# CITY OF ALBUQUERQUE

January 3, 2024

**Re: Proposed Dunkin Drive-Through TIS  
3520 Menaul Boulevard NE  
HT#H16D122**  
Report dated December 14, 2023  
Engineer's Stamp -----  
Via email laboona@kloainc.com

C100

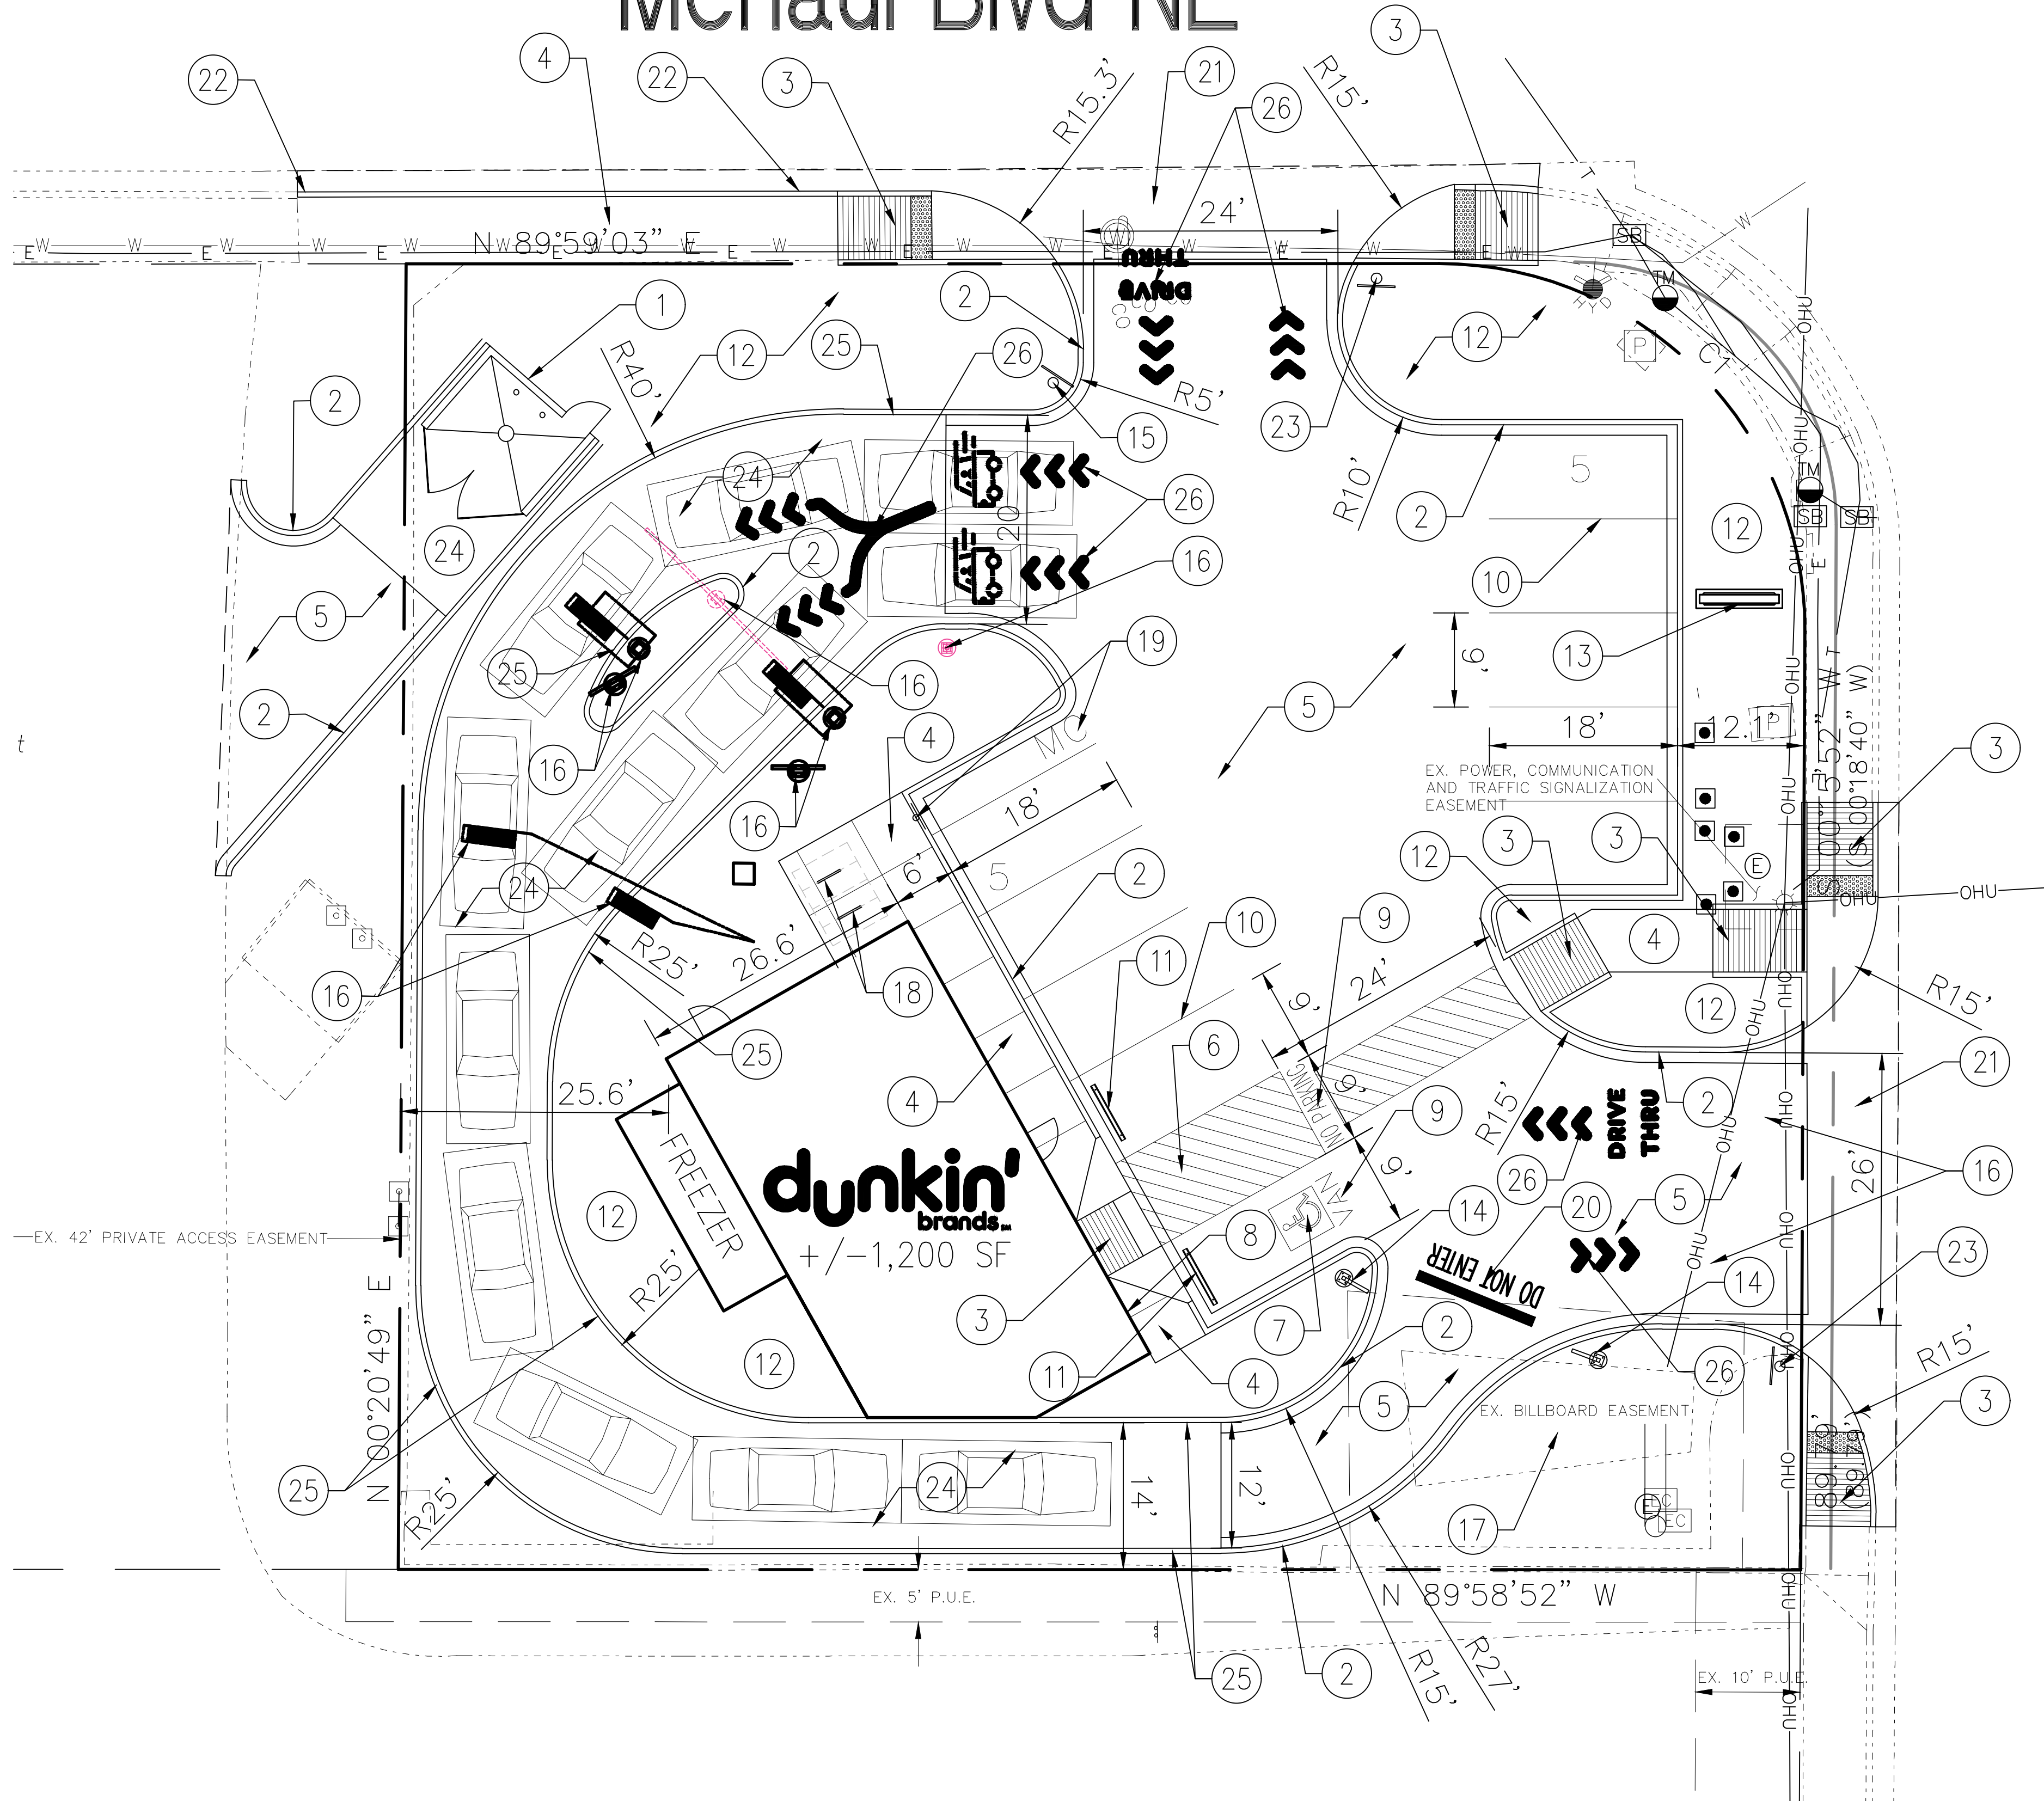
- The proposed access on Menaul Blvd., an existing driveway, is too close to the approach of the intersection of Carlisle Blvd. When an access is located on a Principal Arterial approaching an Arterial the minimum distance for a commercial access from the intersection is a minimum 300 feet. Refer to CITY's DPM TABLE 7.4.45 Minimum Distance Between Commercial Site Access and Intersection. The driveway should be relocated to comply with the City's access location requirement. If the driveway is not relocated to be in compliance with the City's DPM an approved waiver, see TABLE 2.1.1 Summary of Development Procedures, is required before the TIS can be finalized for approval by the City.
